# ENG-PUDSP22005-R2-GEC redlines.pdf Markup Summary

**Subject:** PolyLine  
**Page Index:** 2  
**Date:** 10/17/2022 11:24:03 AM  
**Author:** dotprete  
**Color:** ■  
**Layer:**  
**Space:**  
**Page Label:** 2 INITIAL GECP

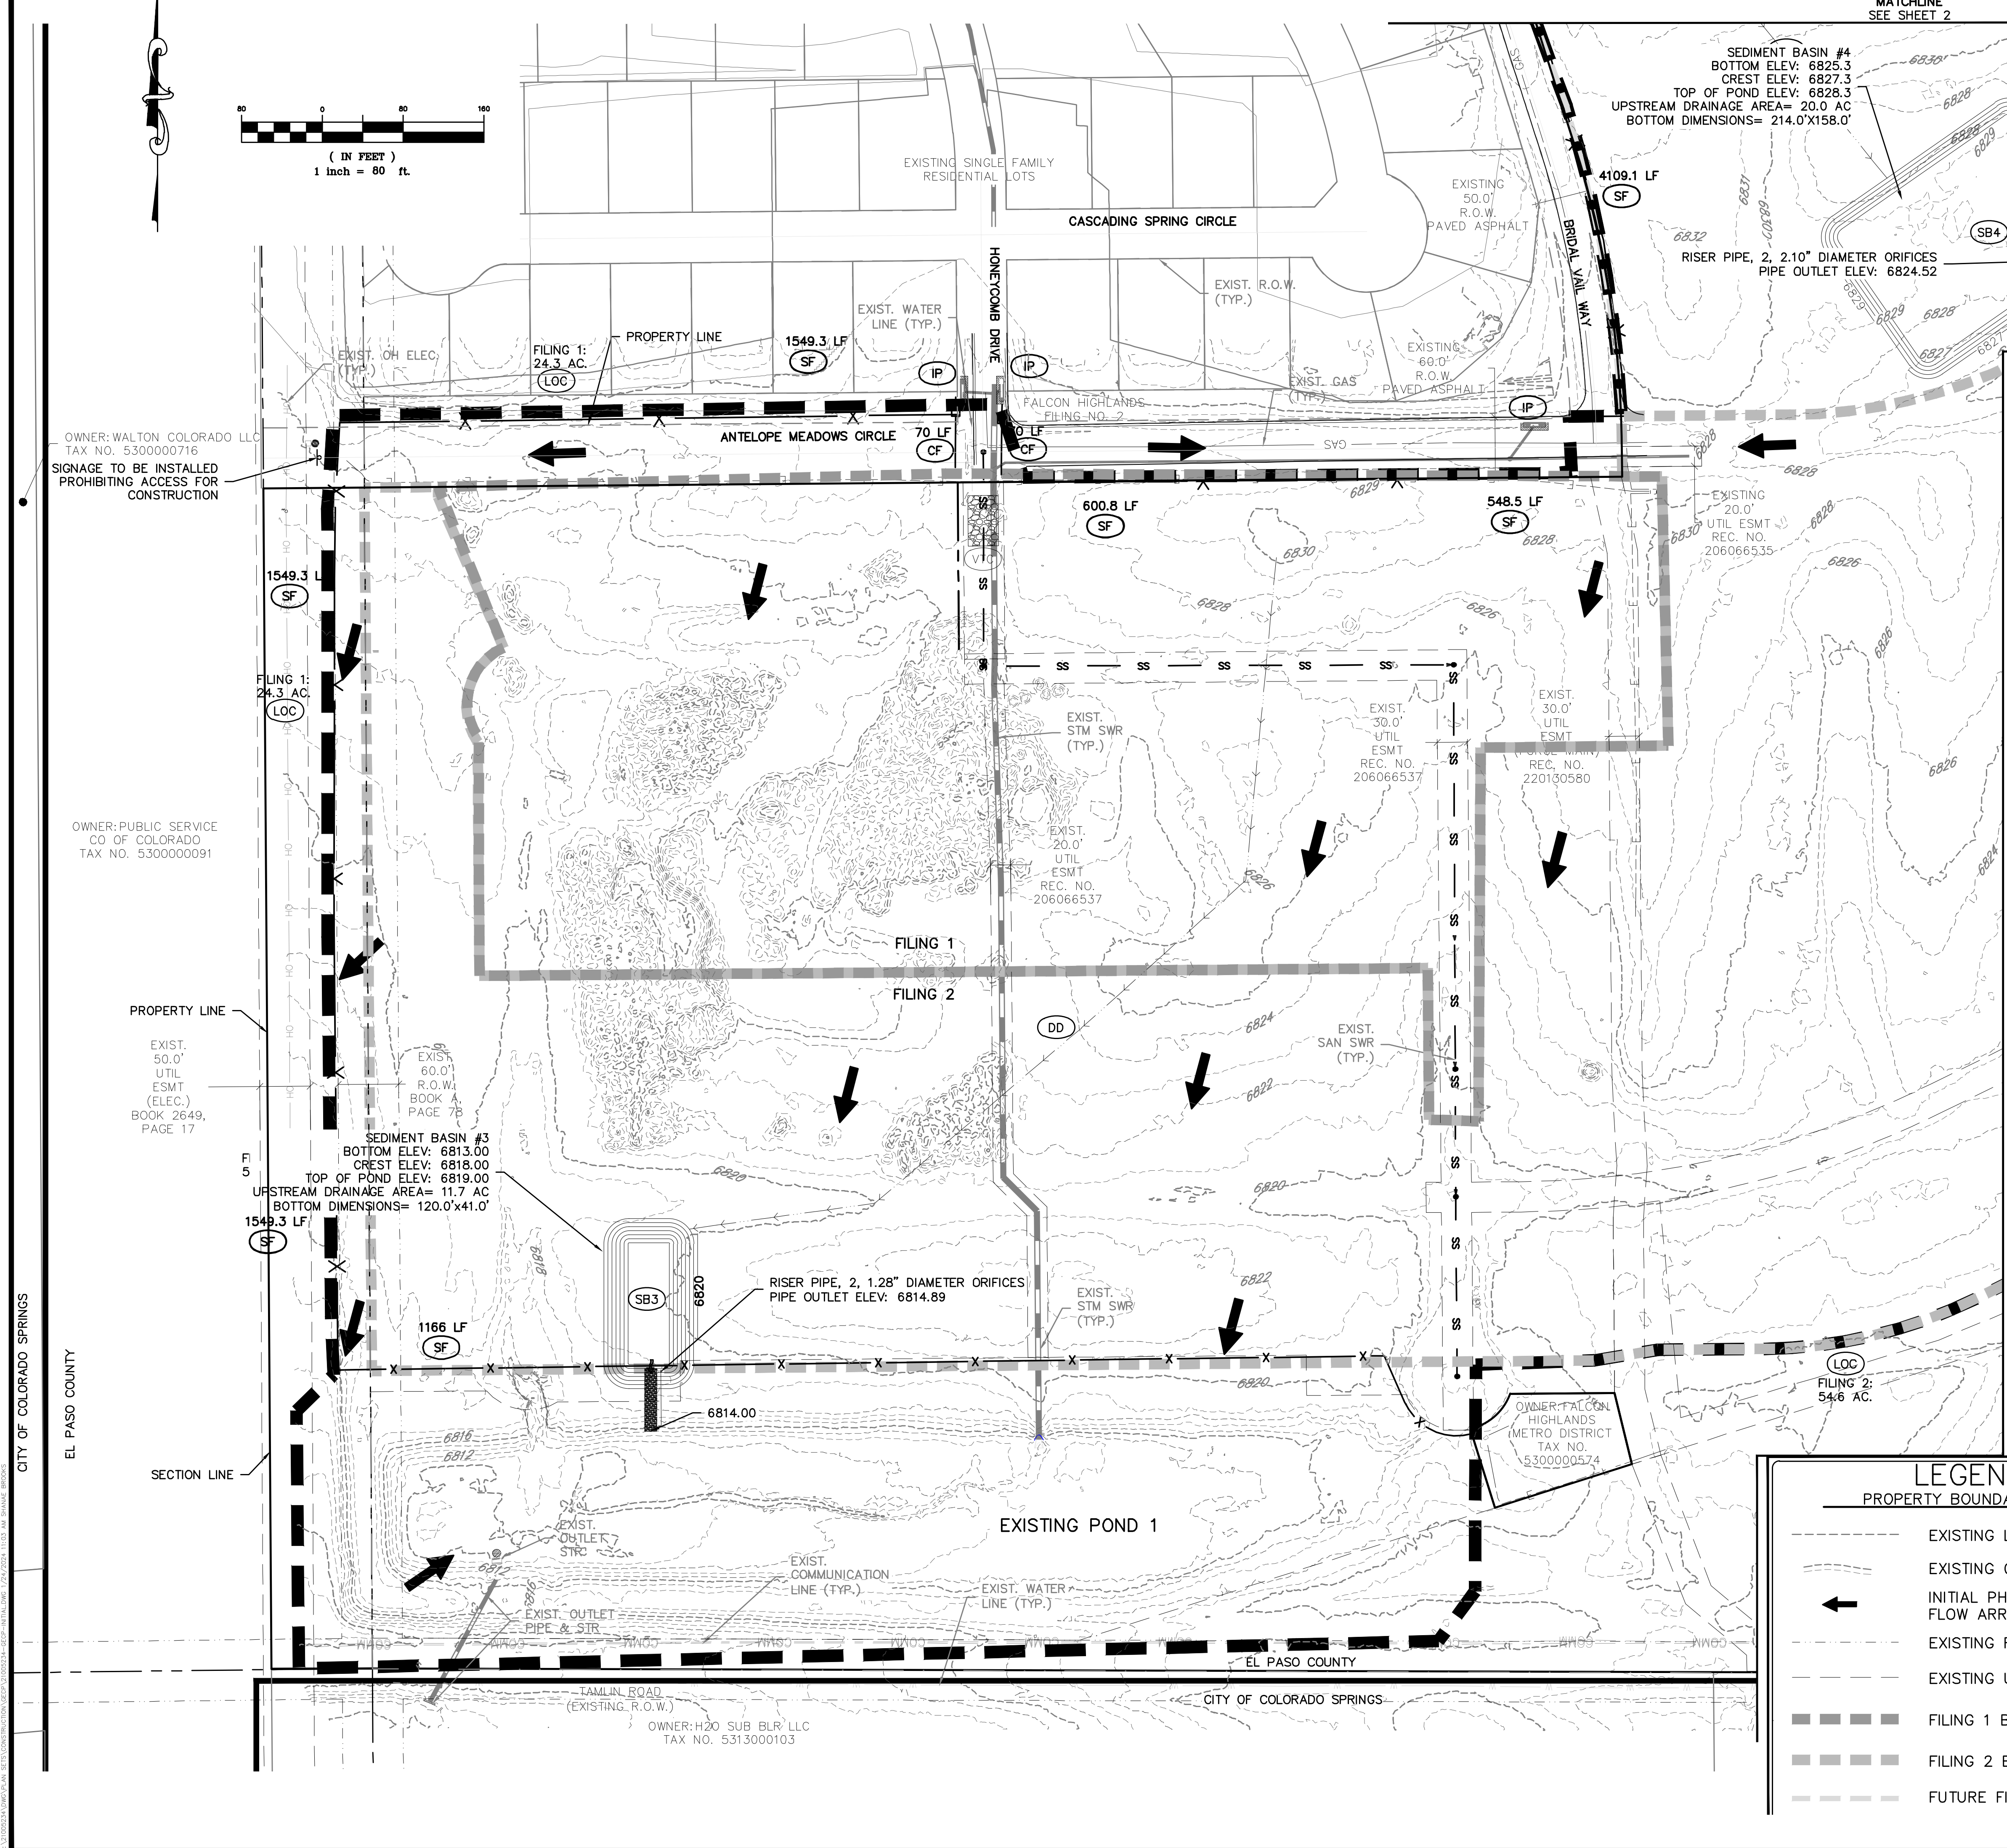
stormwater from this grading area should be treated via a TSB prior to entering the existing pond.

where will this TSB discharge to? show contours, location of spillway and discharge pipe.

provide inlet protection

provide construction fencing, barricades, and/or signage at access points not to be used for construction.

adjust match line to show all of the TSB

show all existing pond features (inlet, trickle channel, forebay, spillway, etc.)

4

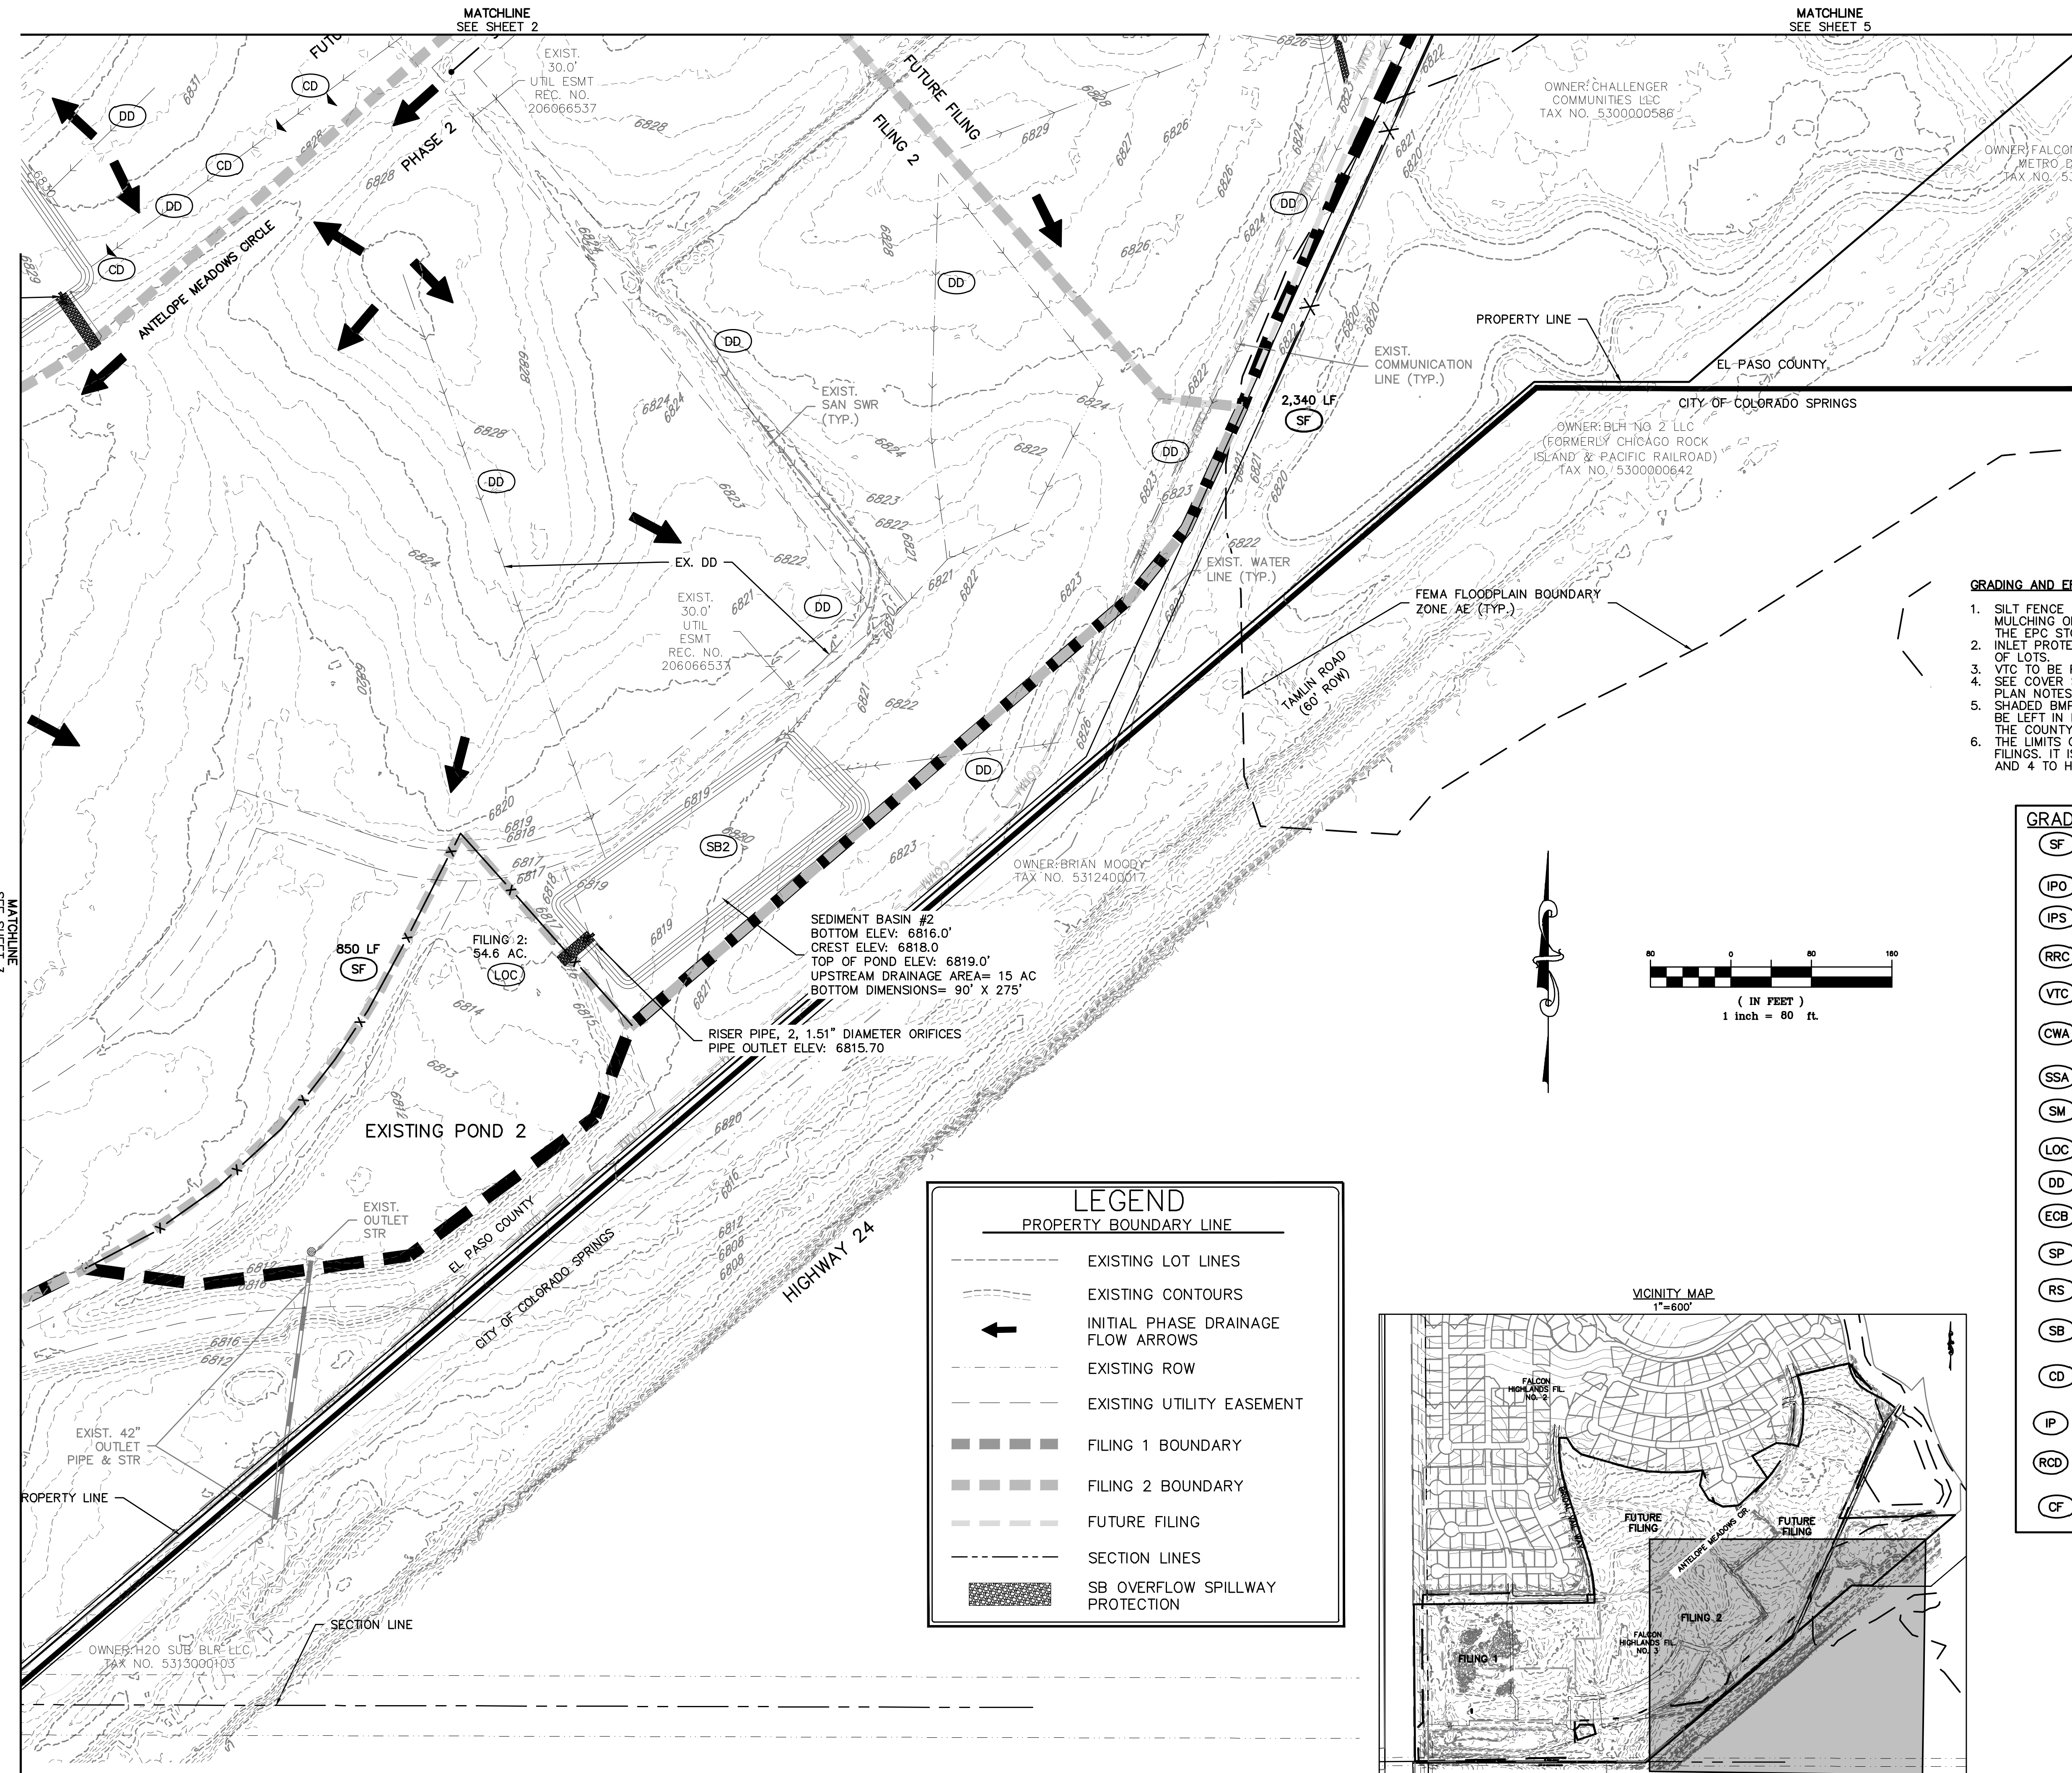
stormwater from this grading area should be treated via a TSB prior to entering the existing pond.

continue DD to TSB

where will this TSB discharge to? show contours, location of spillway and discharge pipe.

show all existing pond features (inlet, trickle channel, forebay, spillway, etc.)

is this ditch existing, as described in the DR? If so, show existing contours

JOB: 21005234
SHEET NO. 6

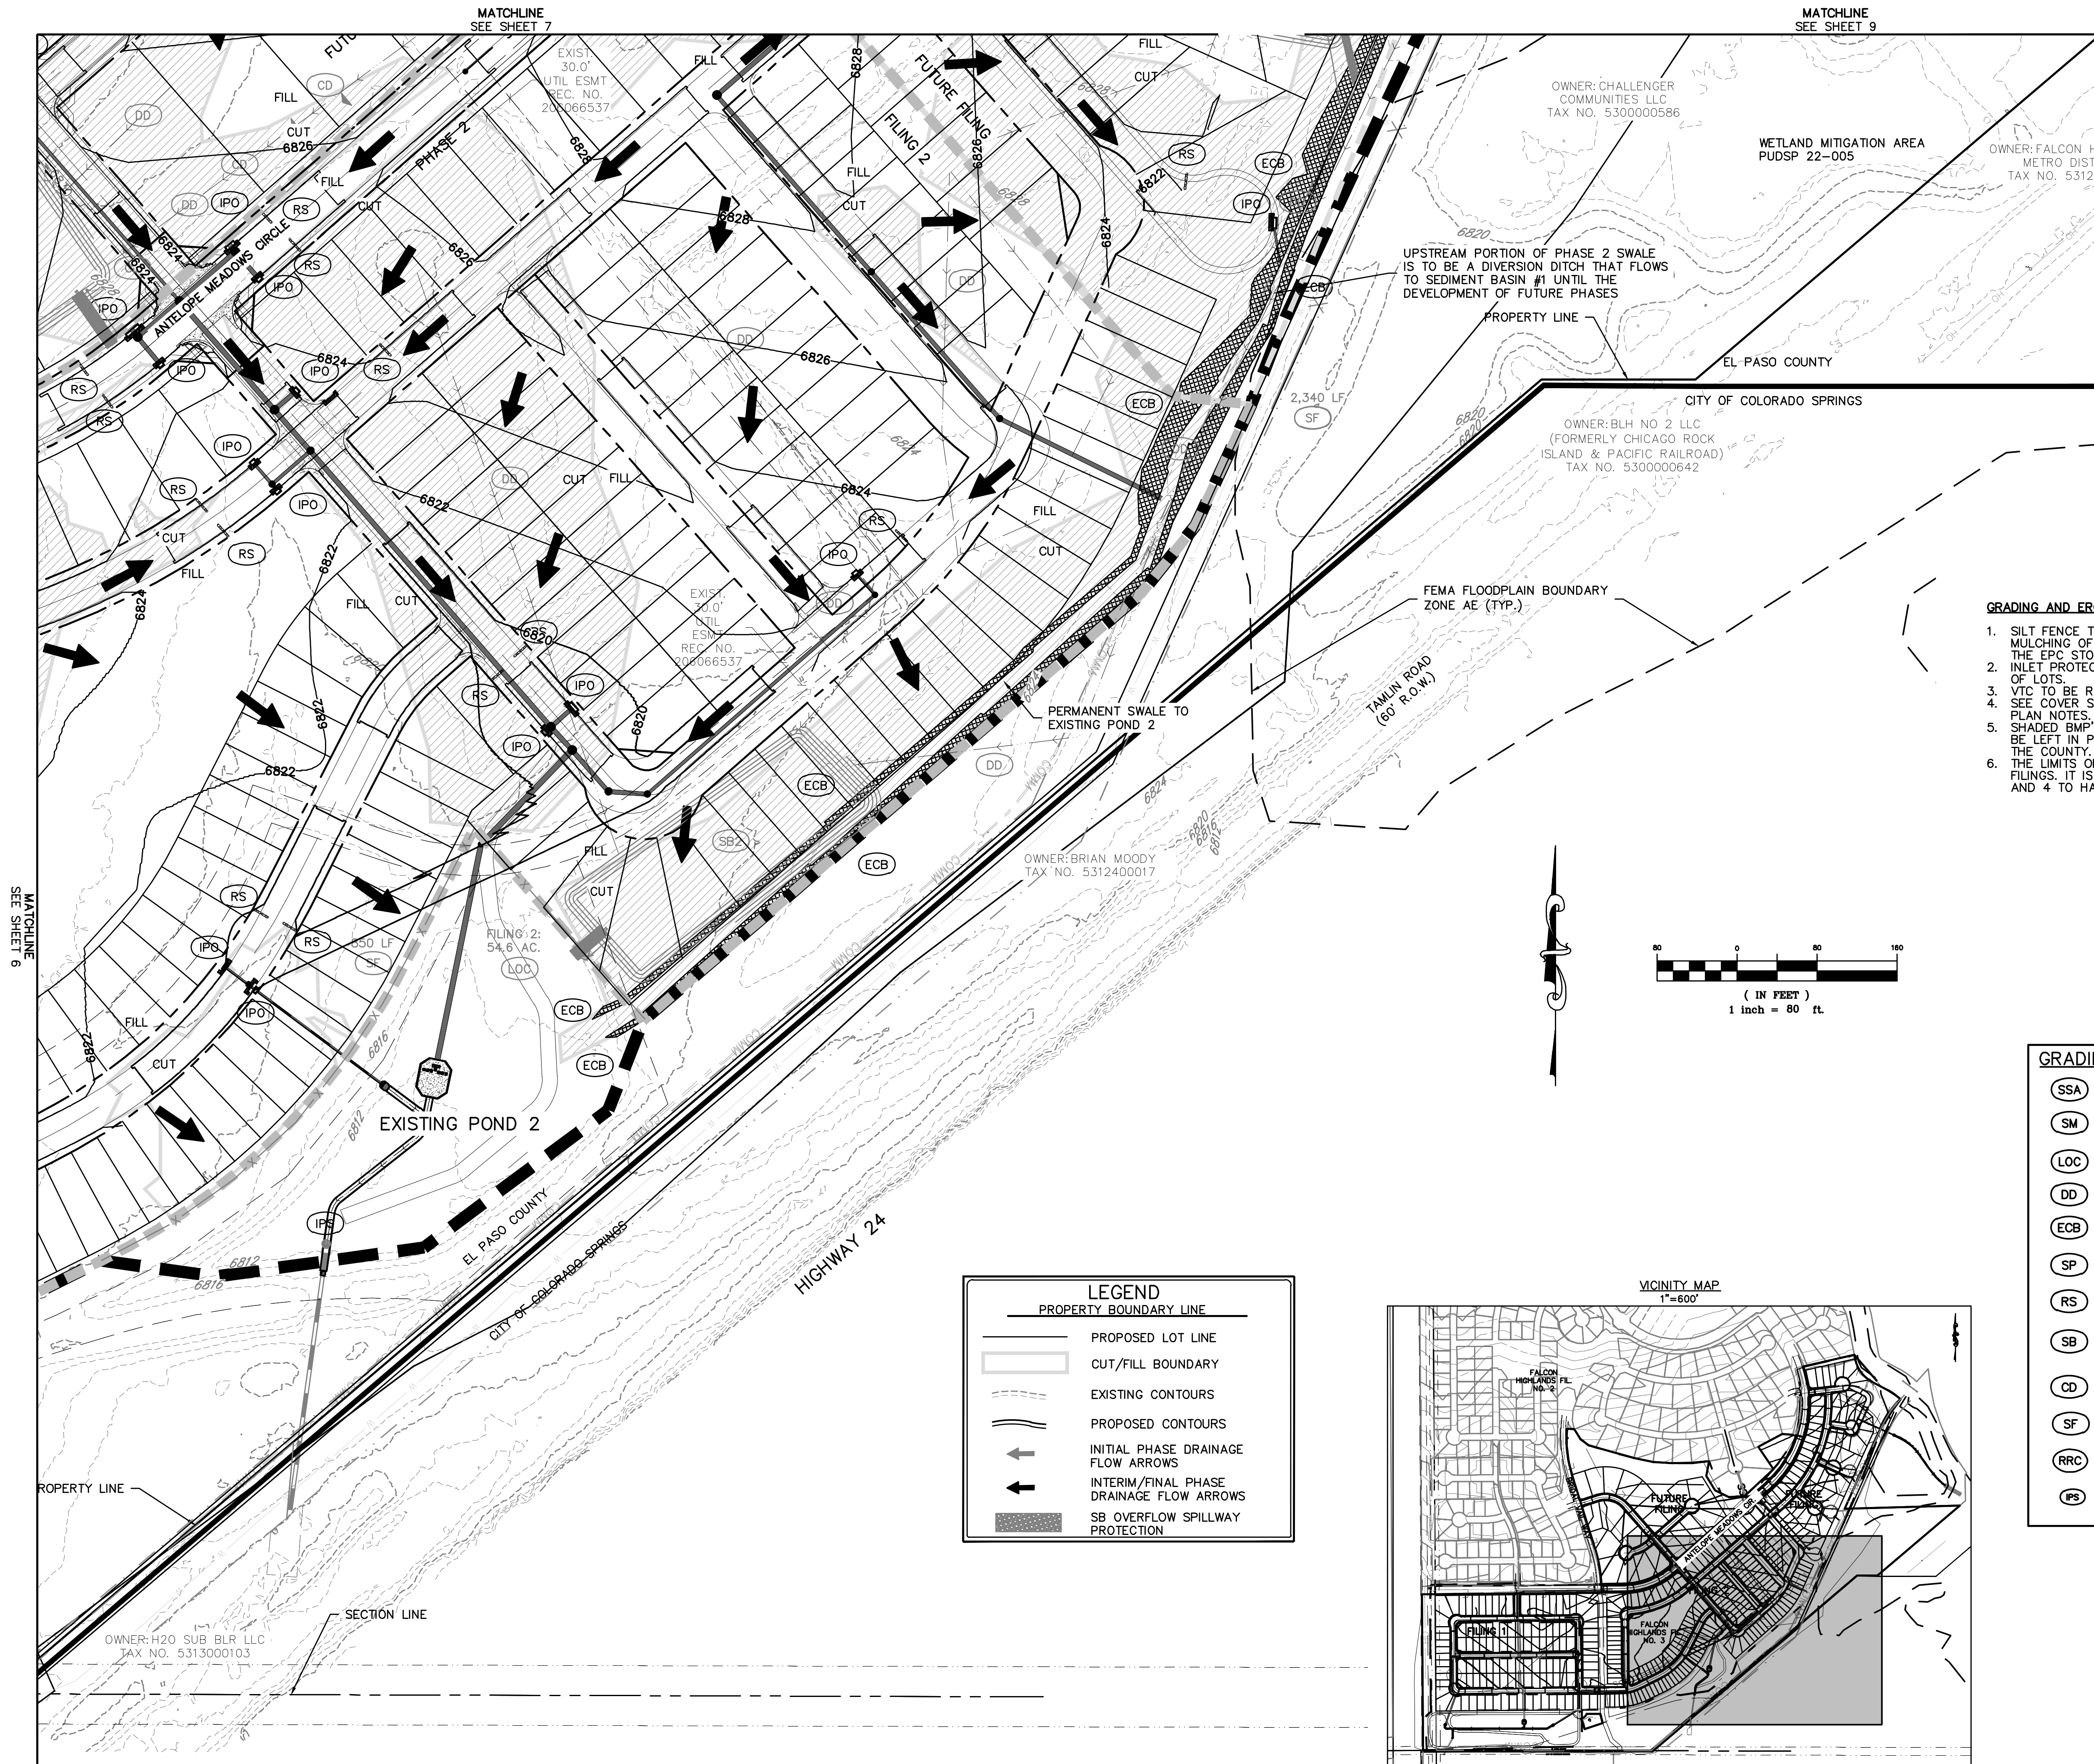
some of these arrows seem to be pointing in the wrong direction

show how proposed contours tie into existing

please match interim and final plans to the same order as the initial sheets

existing, proposed or future?
